Office of
Environment
& Heritage

RE: Yarrabee Solar (SSD 9237) – Exhibition of Environmental Impact Statement

ATTACHMENT A – OEH Assessment Summary for Yarrabee Solar Environmental Impact Statement (SSD 9237)

ATTACHMENT B – Detailed comments for Yarrabee Solar Environmental Impact Statement (SSD 9237)

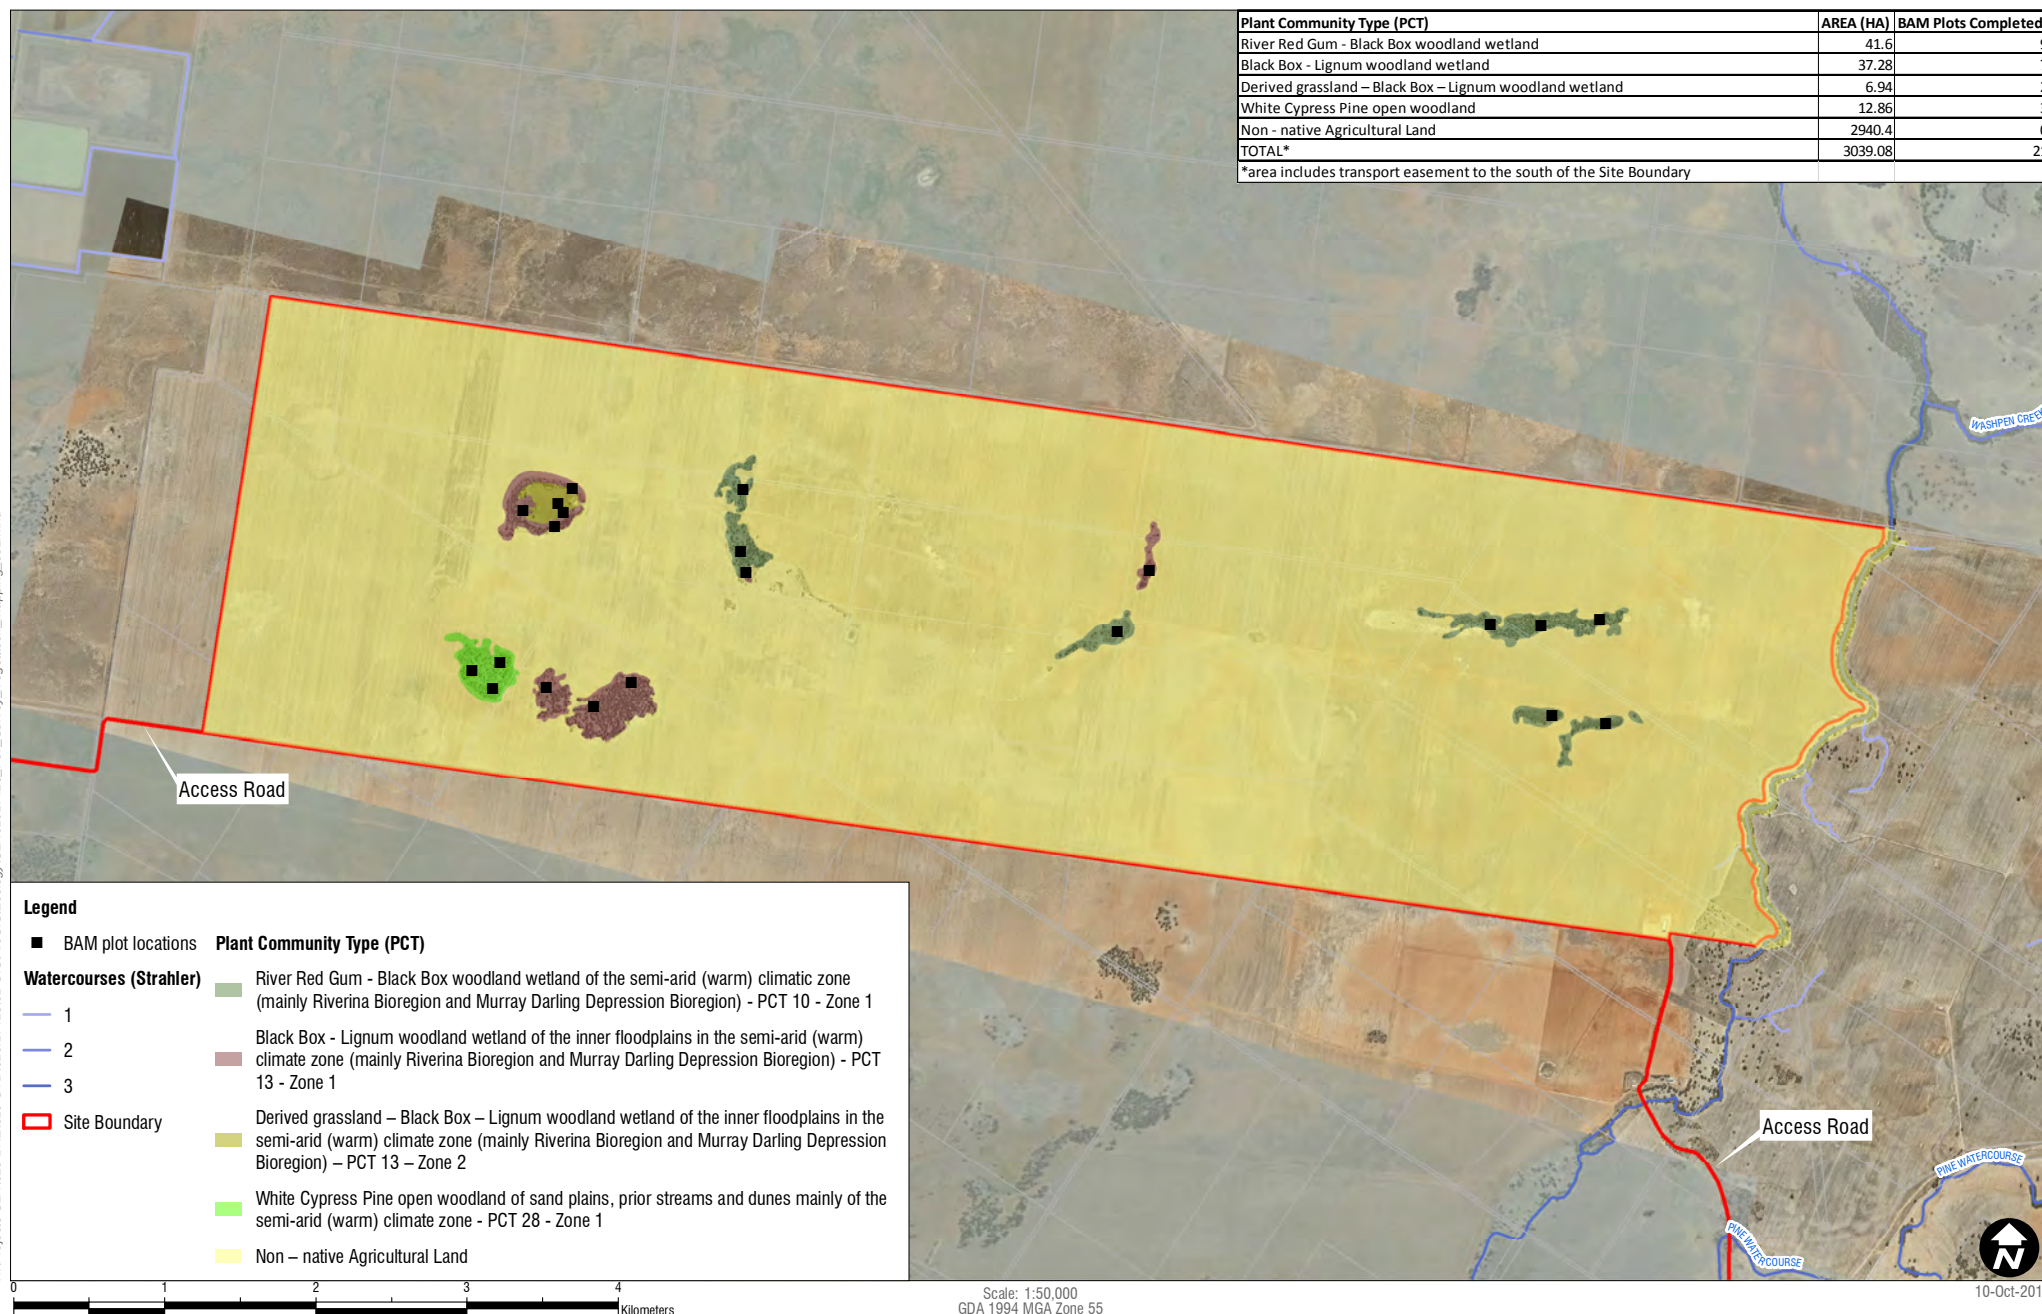
The three vegetation types identified for the development site (page 33) do not include native grassland. The list of fauna habitats present on the site includes a native grassland.

Native grassland habitat is shown on Figure 8 'Habitat Features' (page 42). This area is mapped as non-native vegetation on the plant community type (PCT) mapping on Figure 7 (page 35).

This area is also mapped as native grassland on the existing regional vegetation mapping. OEH accept that regional-scale maps may be less accurate at a site scale. The BAM Section 5.1.1.6 requires that inconsistencies between regional vegetation mapping (as shown on Figure 6) and results of the vegetation survey for the Yarrabee Solar development site (section 2.3.1 and Figure 7) should be demonstrated through field survey results.

- *Demonstrate that open areas of pasture do not meet the definition of native vegetation or do not require further assessment according to the BAM section 3.1.1.3. Pasture that is part of a regular cropping rotation can be evidenced by aerial imagery with cultivation marks.*
